From: [REDACTED]
Sent: 23 December 2019 11:16
To: Amber Willard <Amber.Willard@arun.gov.uk>
Subject: RE: Y/100/19/A

Y/100/19/A

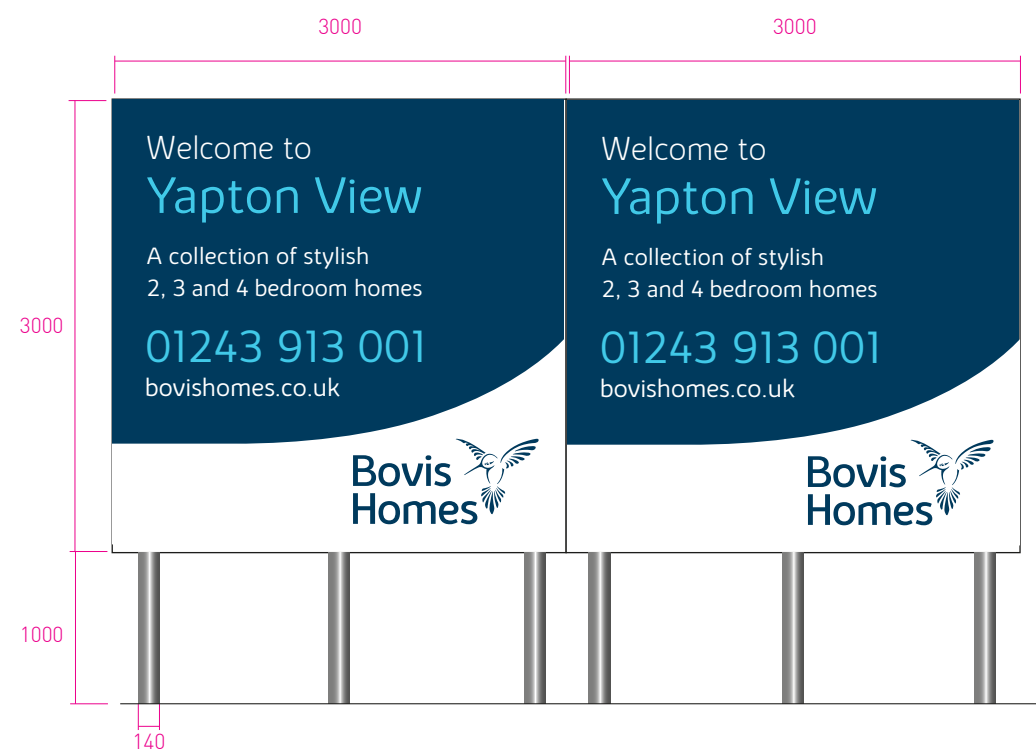
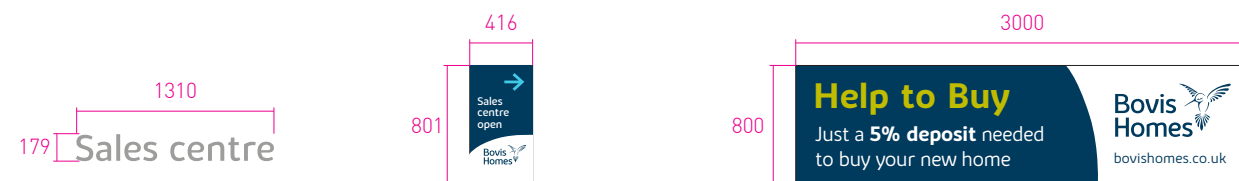
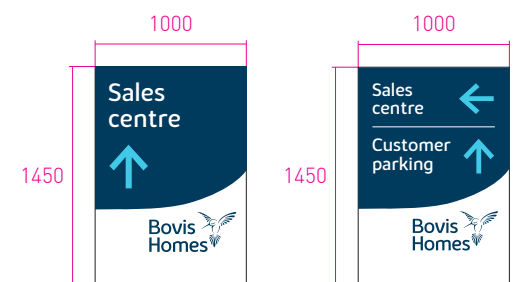
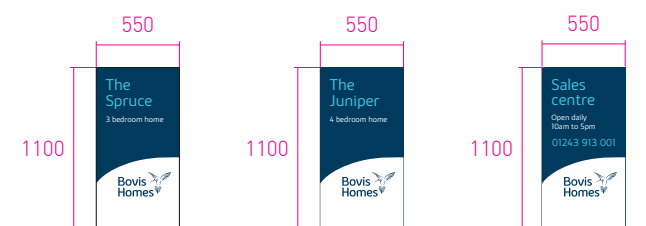
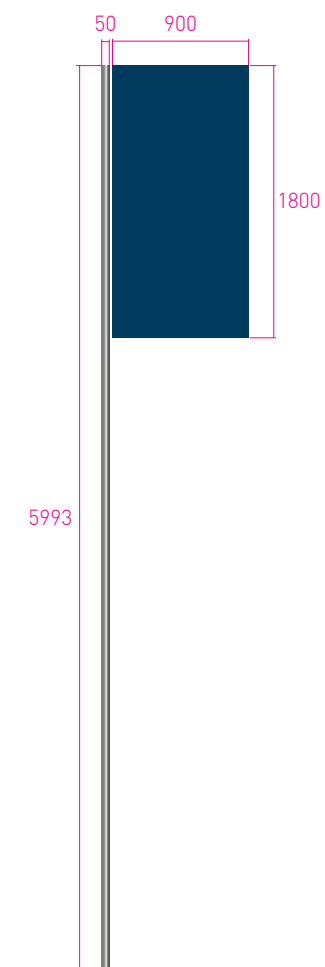
- I am unable to find K,L,O,M on the 'sales signage' Plan. Please are able to advise where they are on the plan or amend as necessary.
- The application states 2 fence panels and within the covering letter its states' two fence panels (items D and E). However on the 'sales signage' Plan, D is marked at 5 separate locations and E is marked twice. Please can you confirm if this means there will be 7 separate fence panels signs.

We have been advised by the applicant that item K is a movable sign that is stored away and only used on occasion so does not require advertisement consent. Please note that the applicant has decided not to install item L and therefore no longer forms part of the application. Item M is already marked out with the red dots on signage plan. Item O on the signage plan is plot markers and therefore does not require consent.

For clarity, the application seeks consent for:

- Item A – main totem V board x 1
- Item B – medium totem x 1
- Item C – medium totem x 1

Item D – fence panels x 11
Item E – fence panels x 2
Item F – wall panels x 2
Item G – small totem x 1
Item H – small totem x 1
Item I – small totem x 1
Item J – ACM cut letters x 1
Item F – flags x 32
